A38 DERBY JUNCTIONS SCHEME (TR010022)

Written Summaries of Oral Contributions at Issue Specific Hearing relating to the Draft Development Consent Order

Representation on Behalf of Derbyshire County Council as an Interested Party

Issue Specific Hearing Relating to Draft Development Consent Order

Drawing Title  
FIGURE 2.7  
LITTLE EATON JUNCTION  
GENERAL ARRANGEMENT

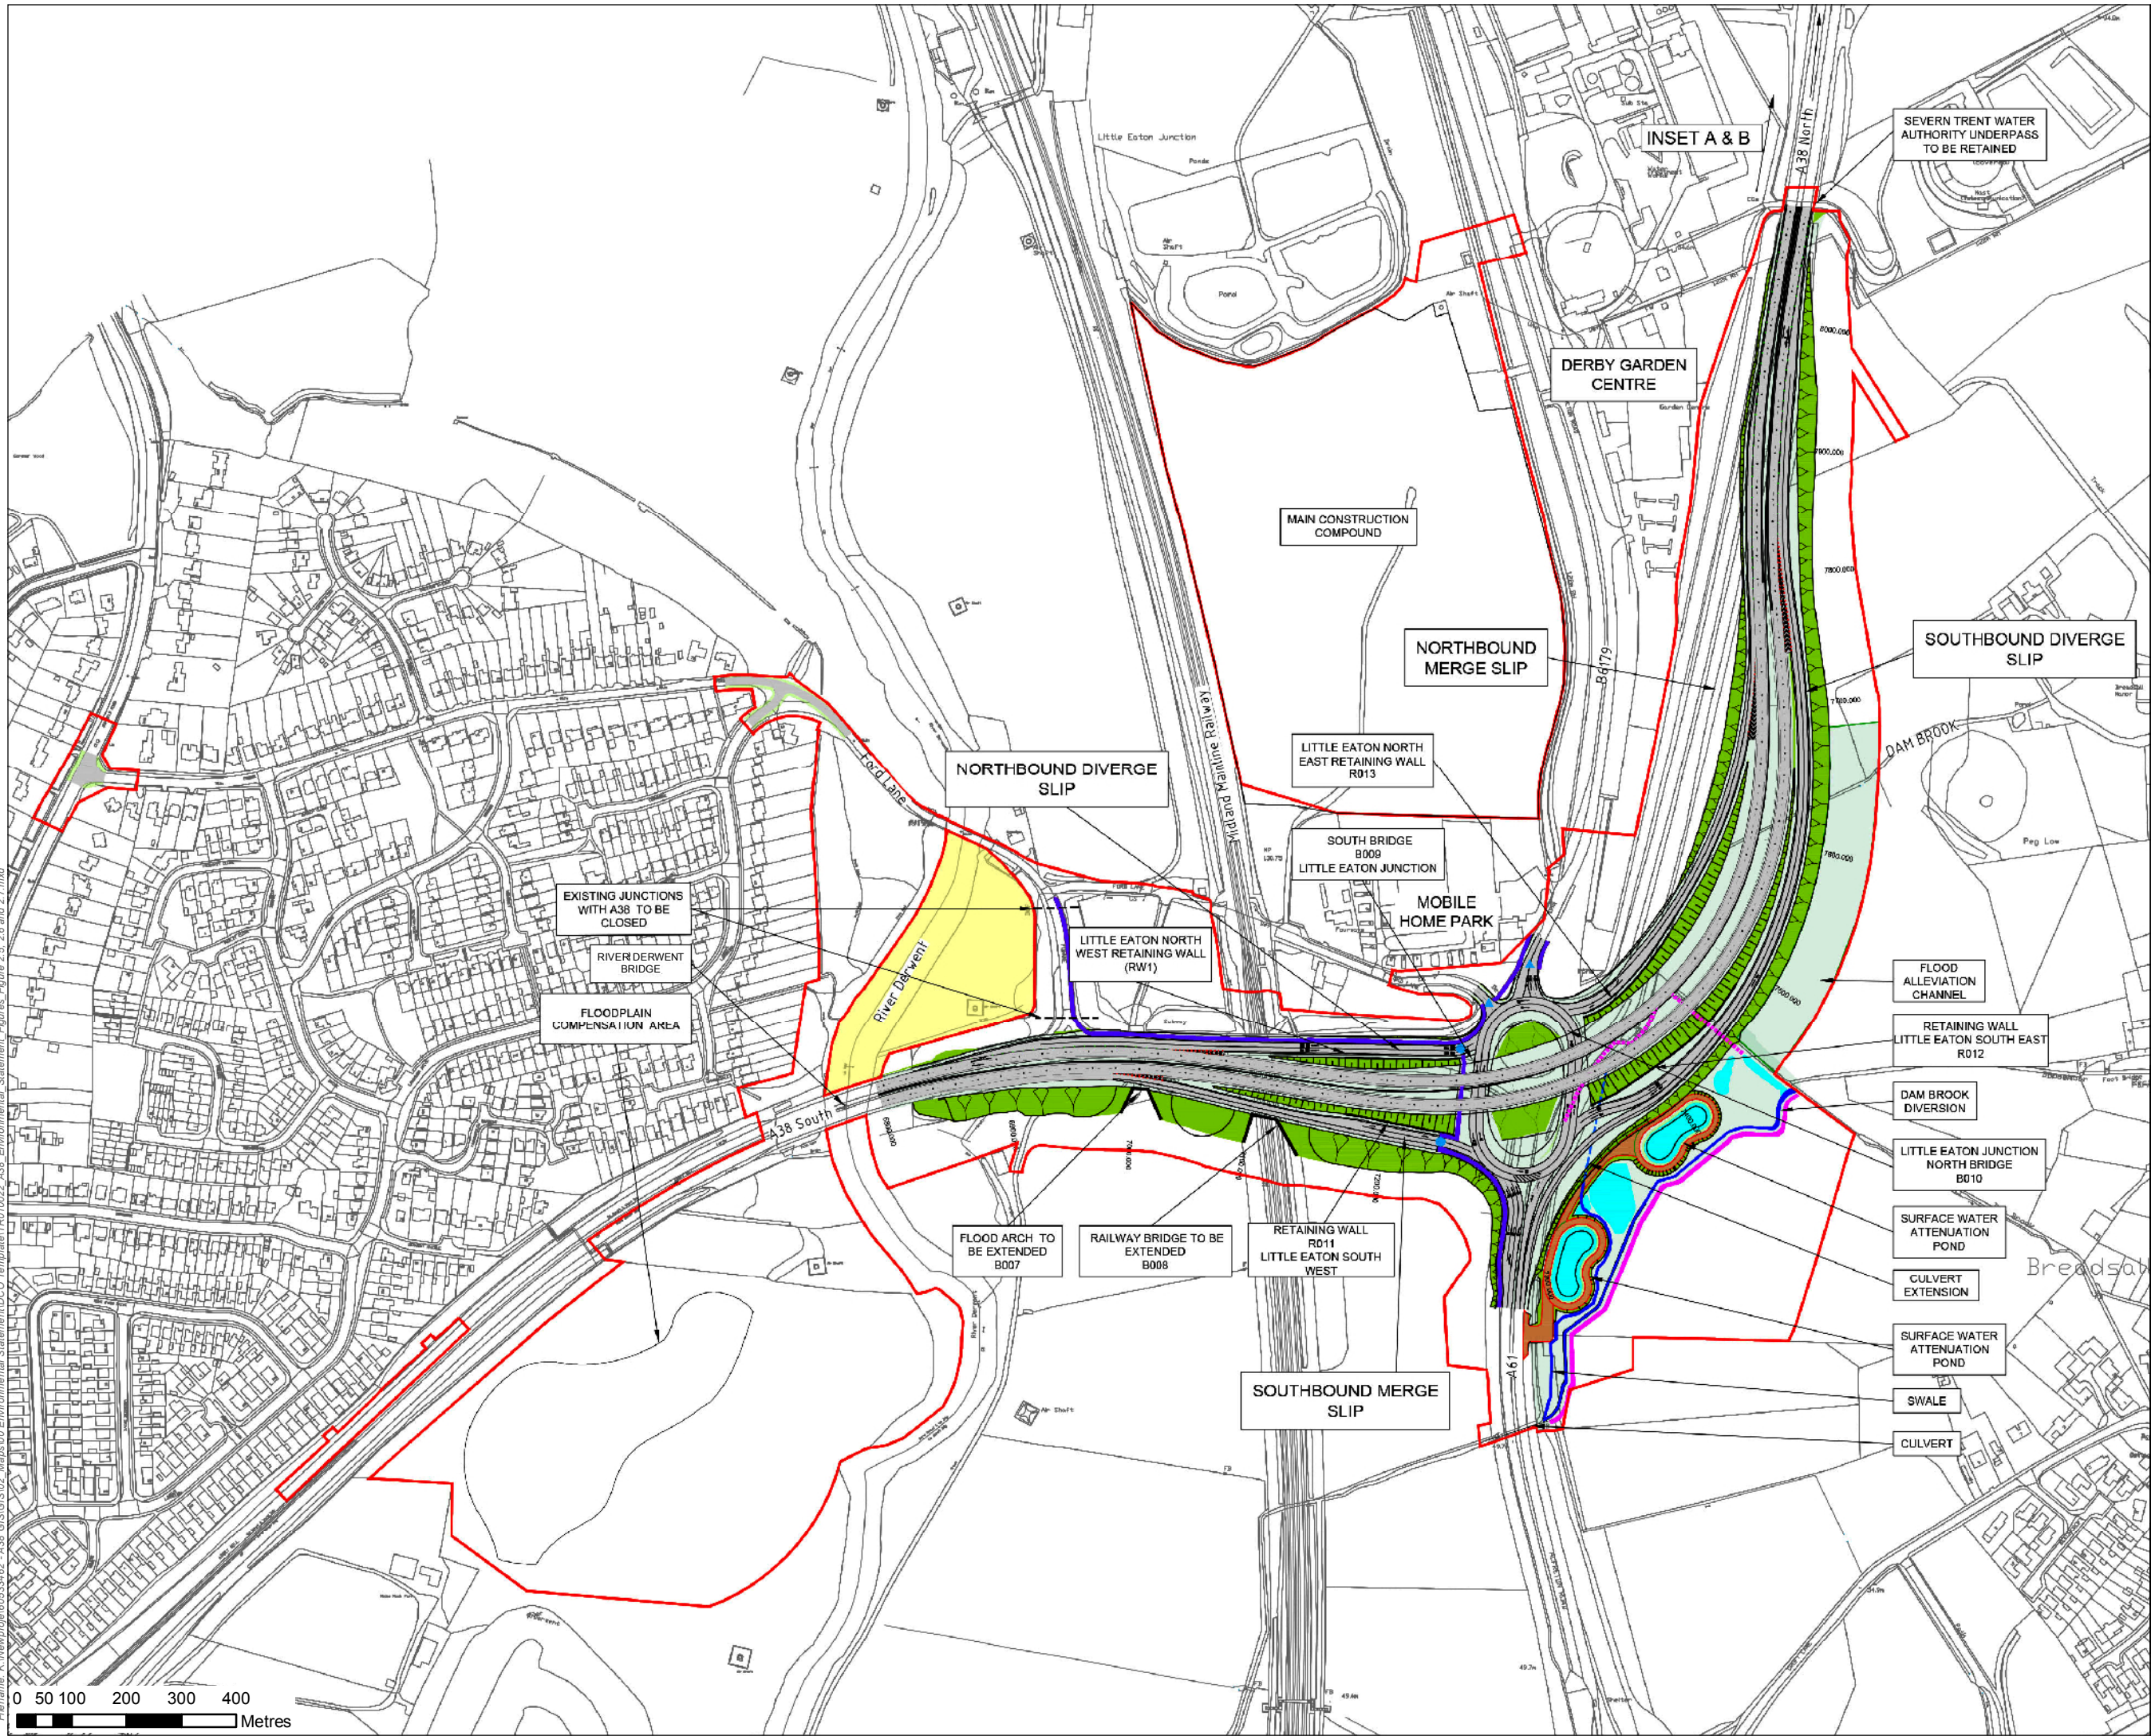
- Derbyshire County Council's officers expressed concern that the applicant has not engaged in any meaningful discussions with the Derwent Valley Mills World Heritage Site Partnership (DVMWHS) on the proposed Little Eaton junction improvements part of the scheme. Derbyshire County Council's officers are represented on the DVMWHS Partnership but the Partnership is a separate body from the County Council, which also includes representatives from Amber Valley Borough Council, Derby City Council and Derbyshire Dales District Council.

- The DVMWHS Partnership has responsibility for producing a DVMWHS Management Plan, which is periodically revised and could have implications for the assessment of the Little Eaton Junctions element of the scheme on the Outstanding Universal Value (OUV) of the WHS. The WHS Management Plan is currently being revised by the Partnership and is (at the time of writing) subject to current stakeholder consultation.

- Derbyshire County Council's representations on the DCO application (Pre-application, Preliminary Environmental Information Report, Section 56 Consultation and forthcoming Written Representations and Local Impact Report submissions) have been made on behalf of the County Council and may not necessarily represent those of the Partnership as a whole. These representations have raised significant concerns with the proposed design of

the Little Eaton junctions scheme and its potential adverse impacts on the OUV of the DVMWHS.

- Derbyshire County Council considers, therefore, that the applicant should now take the opportunity undertake discussion and consultation with the Partnership on the scheme as set out in the Draft DCO and accompanying Environment Statement and seek its expert advice on the potential impacts of the scheme on the OUV of the DVMWHS and how these could be satisfactorily mitigated.
